KITTITAS COUNTY

MEMORANDUM

SUBJECT: Squared Up Short Plat SP-10-00015

The following shall be conditions of preliminary approval:

SQUARED UP SHORT PLAT
 A PTN. OF THE SW 1/4 OF THE SW 1/4 OF SEC. 24, T.20N., R.15E., W.M.
 KITTITAS COUNTY, WASHINGTON

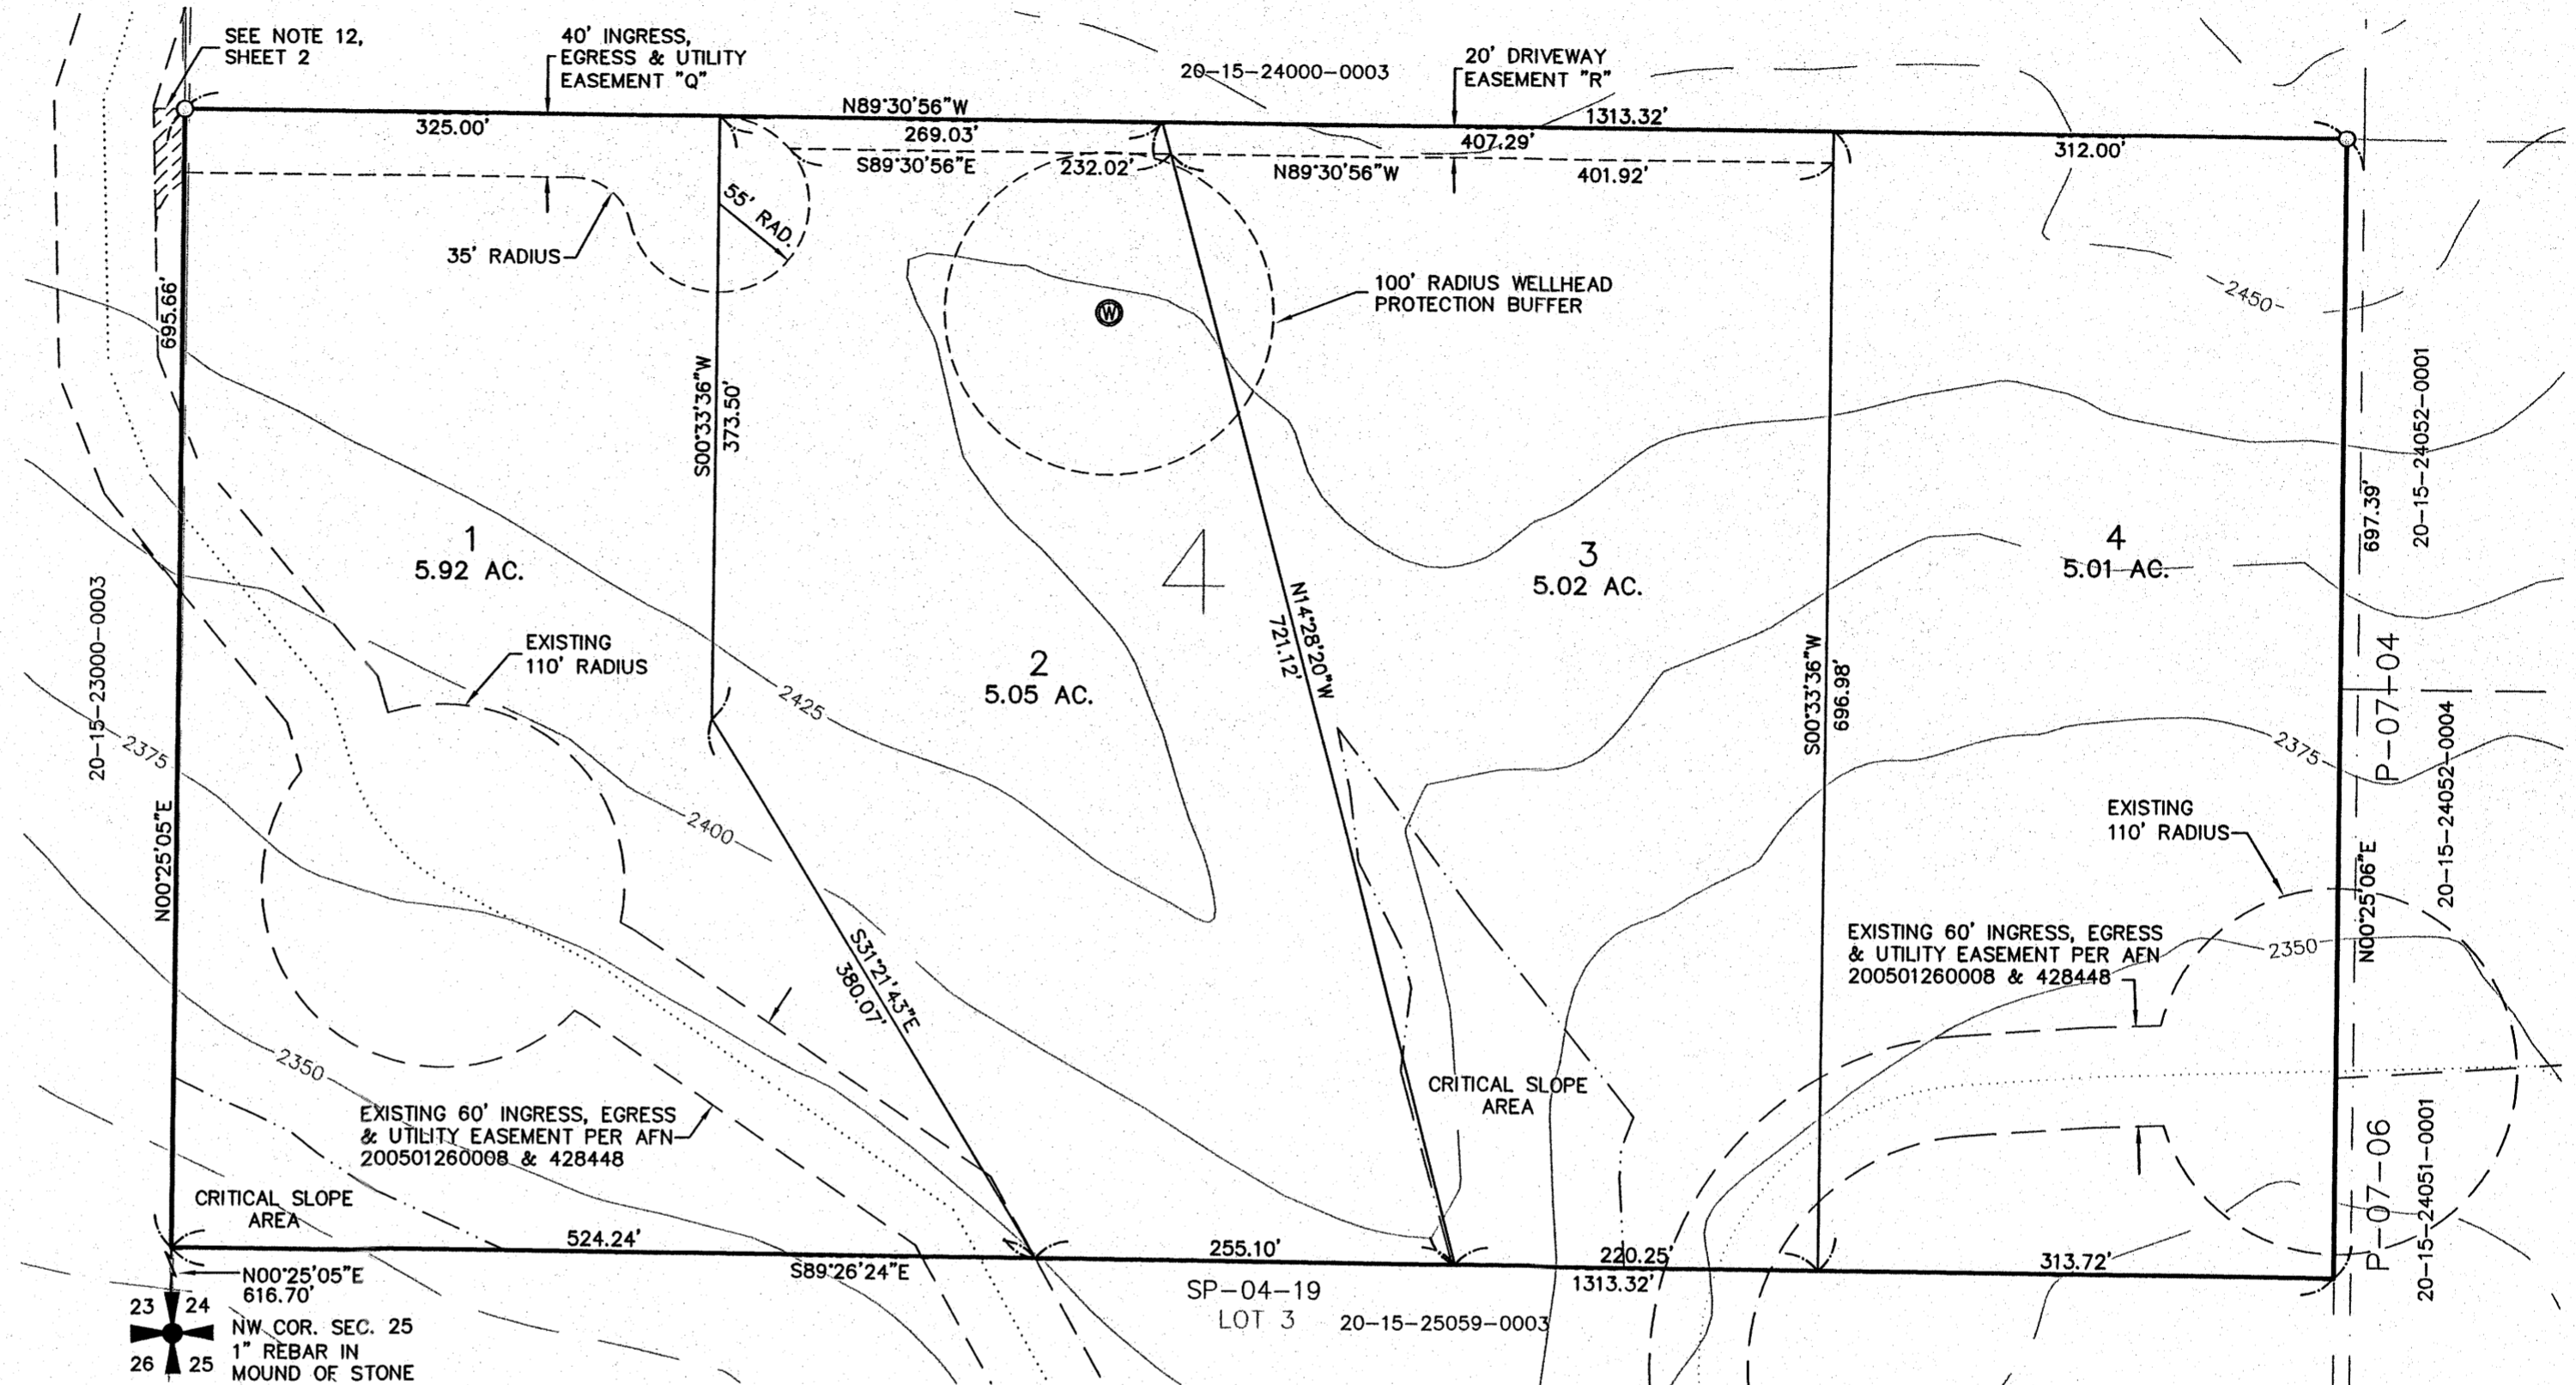
3. Second Access: The second access route shall be shown on the final plat, and the roadway improved and certified prior to the issuance of a building permit. The second access shall be built to the same standards of the primary access. The applicant received a variance approving access through the 30' easement section of Deer Creek Road. Refer to RV-08-37.

4. Access: The portion of easement referred to in Note 12 shall be acquired and recorded prior to final approval.
5. Lot 2 Access: Lot 2 shall be accessed directly off the cul-de-sac or road and not use the driveway easement.

6. Road Names: Jack Pine Drive and Forest Ridge Road shall be labeled on the final plat.
7. Private Road Improvements: Access from Cle Elum city limits to the site shall be constructed as a Low-Density Private Road. See Kittitas County Road Standards, 9/6/05 edition.
